# CITY OF ALBUQUERQUE

**Re: Retail Center Shell for Felix Rabadi, 3500 Menaul Blvd,  
Traffic Circulation Layout  
Architect's Stamp date 5/20/13 (H16-D146)**

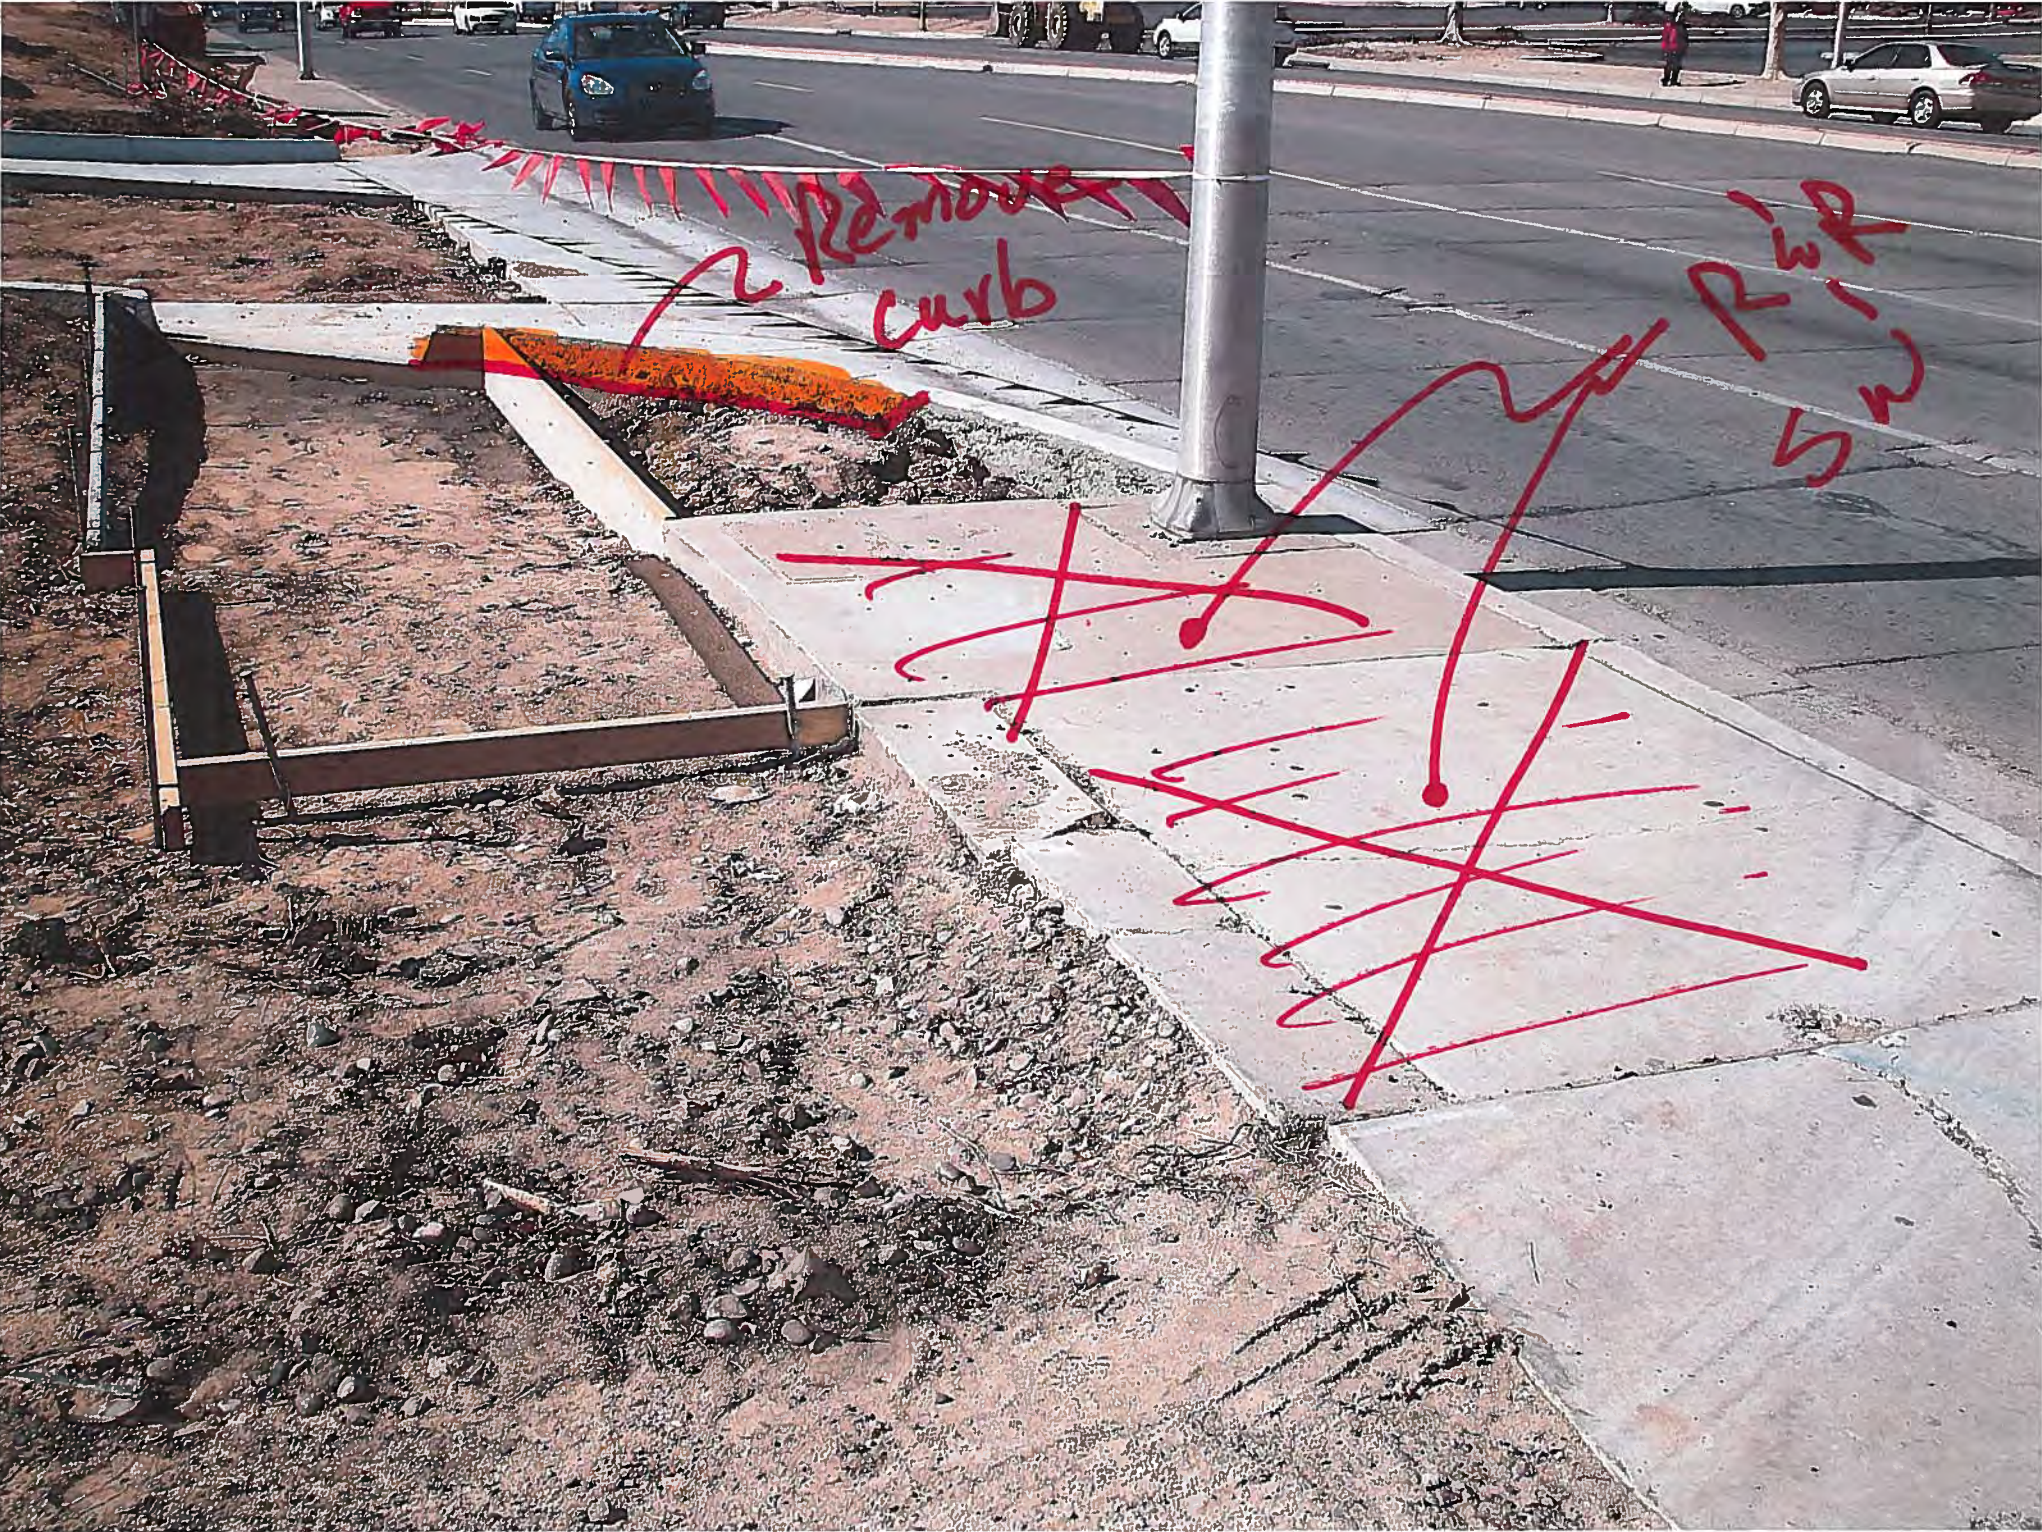
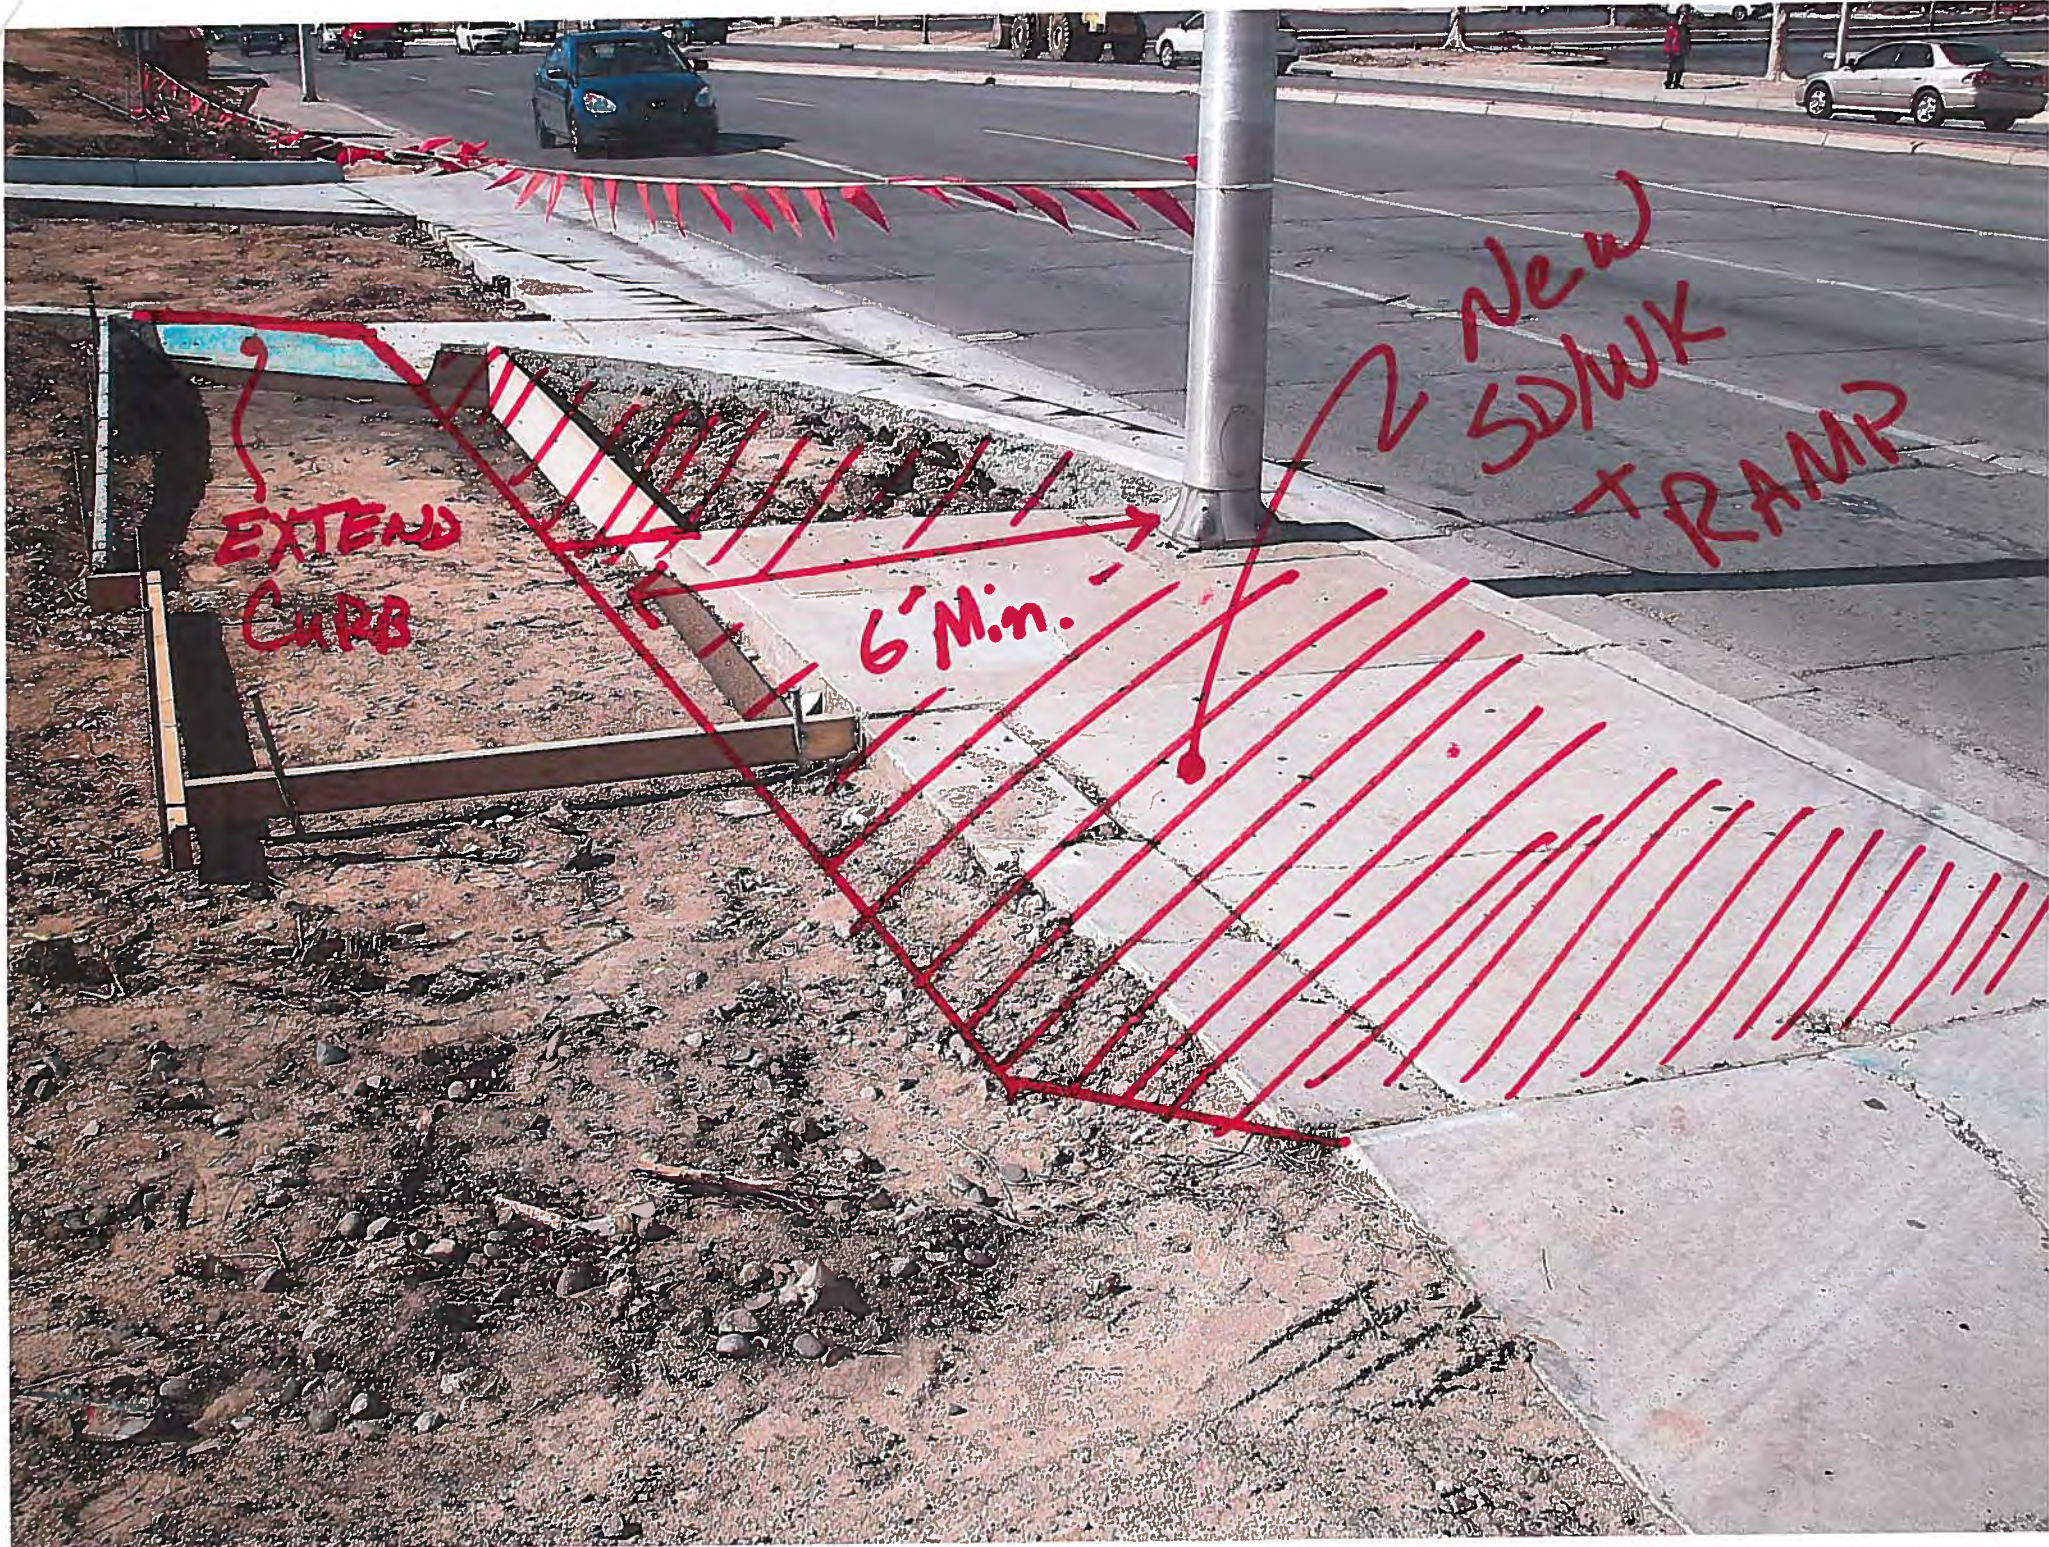
1. The proposed standard parking stalls, 16 ft x 8.5 ft with wheel stops does not meet DPM standards. Standard stall lengths must provide 18 ft. A shorter stall of 16 ft can be applied if there is a minimum of 2 feet available for vehicle overhang (ex: landscape buffer, 8 ft sidewalk). Please correct deficiency.
2. Please clarify what is proposed at motorcycle stalls with the two 9" dimensions labeled. Please consider providing a barrier at motorcycle stalls/ drive entry to prevent vehicle impact. Parked motorcycles appear vulnerable.
